From: Karl McLaughlin
Sent: 29 November 2017 09:36
To: Ross Leal
Subject: RE: BR/294/17/PL - 21 Lennox Street, Bognor Regis.

Proposed

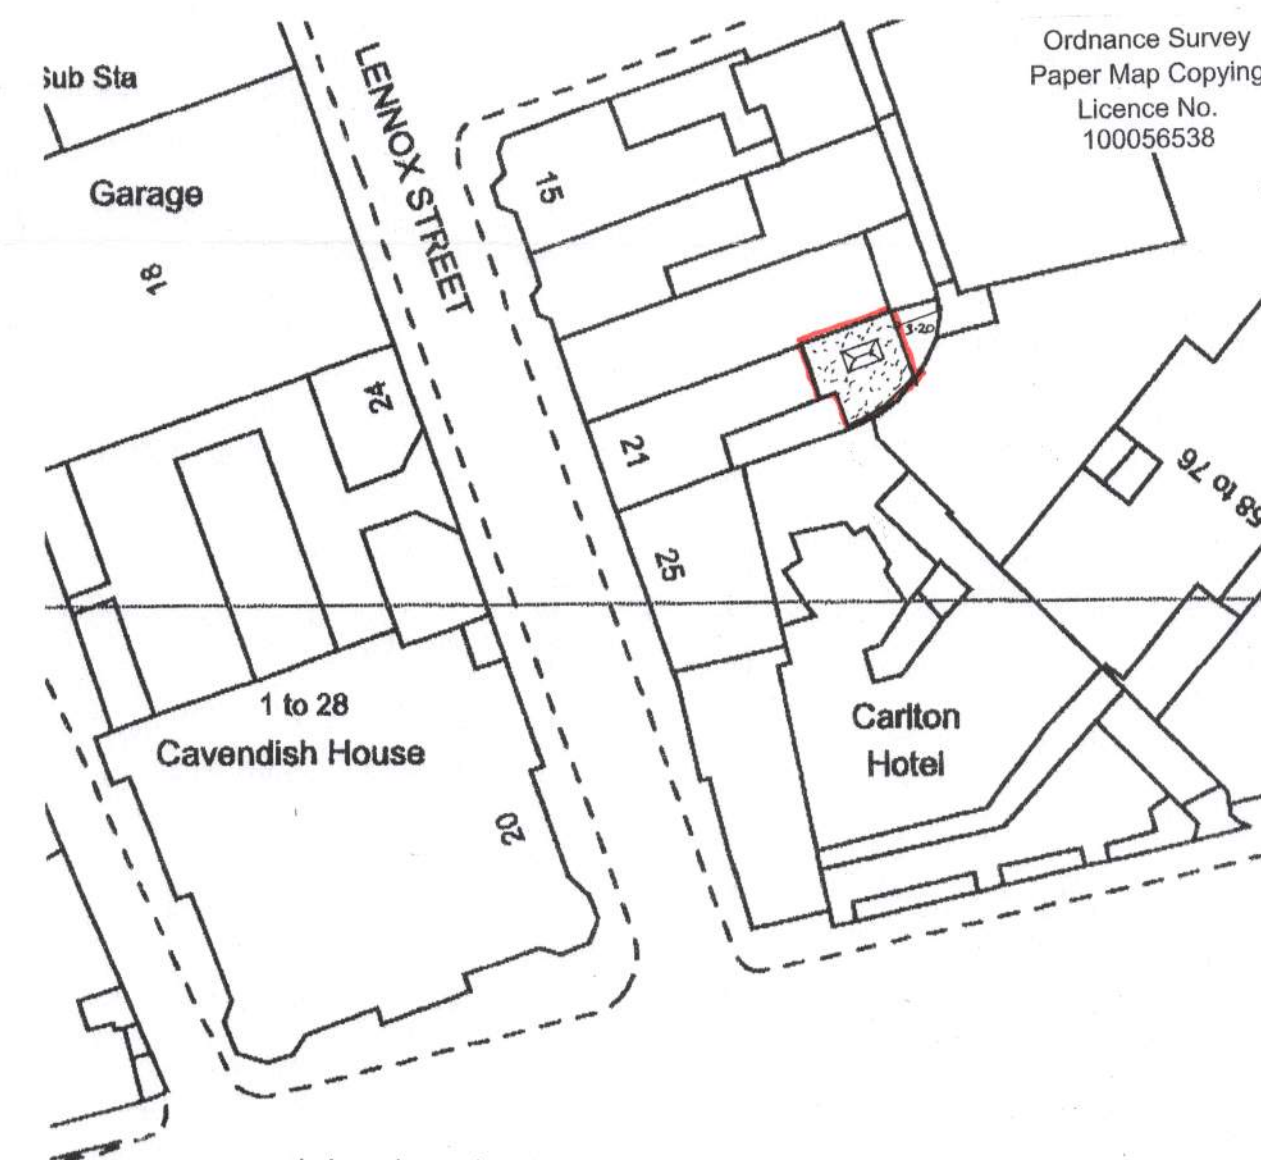
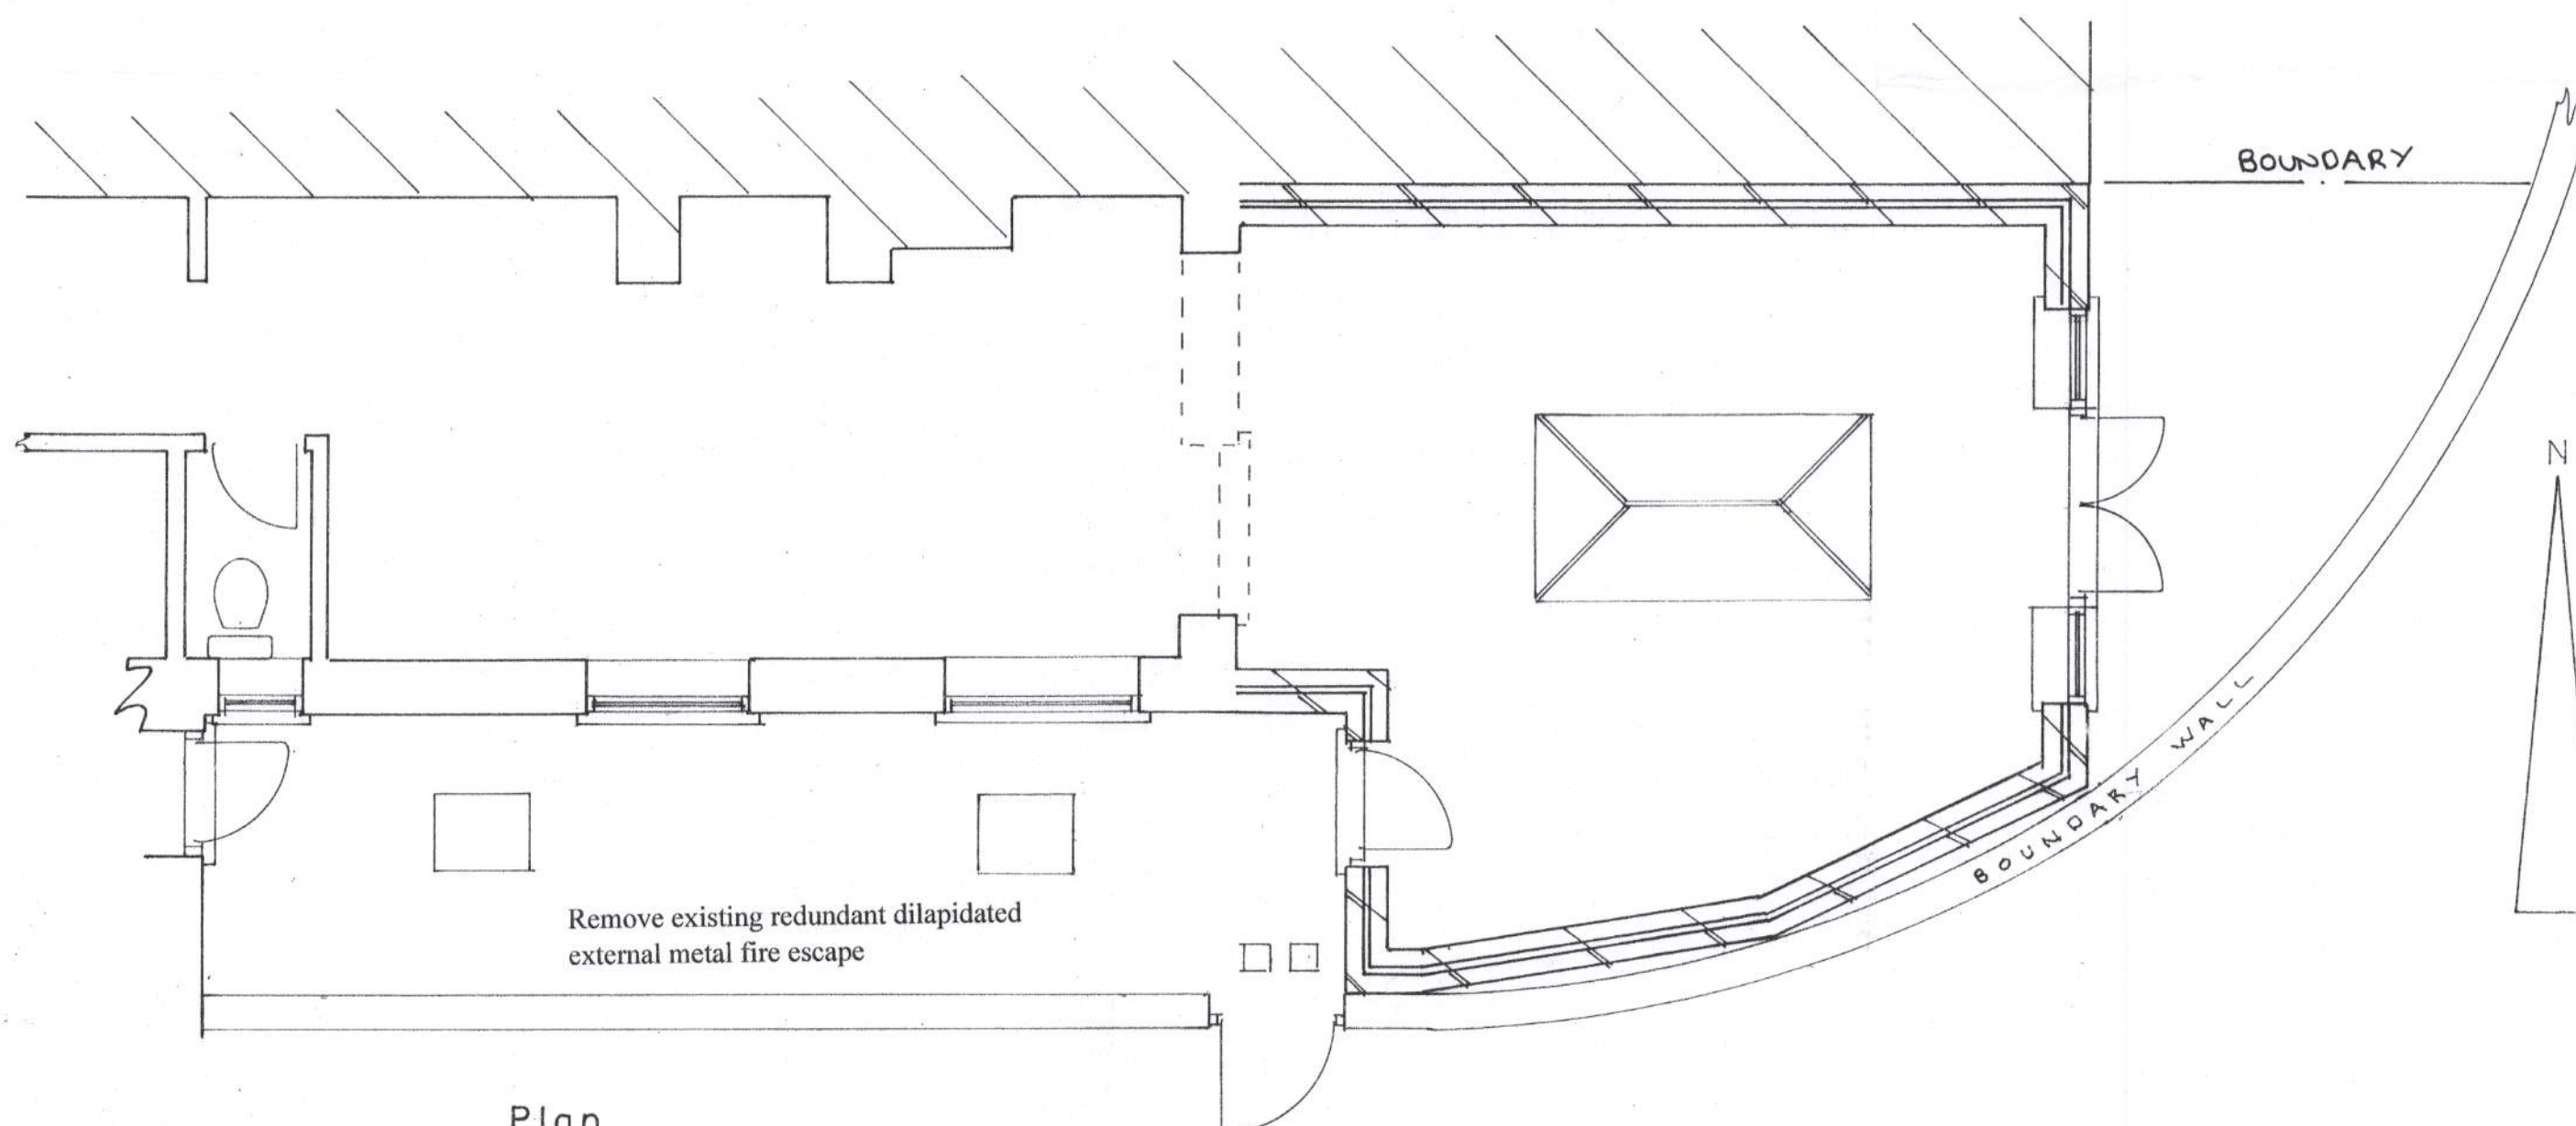
As previously mentioned, I can appreciate that raising the floor level is deemed impractical; this led to the inclusion in my original comment that the provision of flood doors (as per the application) would suffice i.e. **Suitable flood risk measures be provided and maintained to all external doors in perpetuity to the satisfaction of the LPA.** This could be achieved as set out in the application's flood risk assessment, i.e. "Provide 600mm high plastic OR aluminium flood boards in watertight channels fixed to door frames in event of possible flood warning."
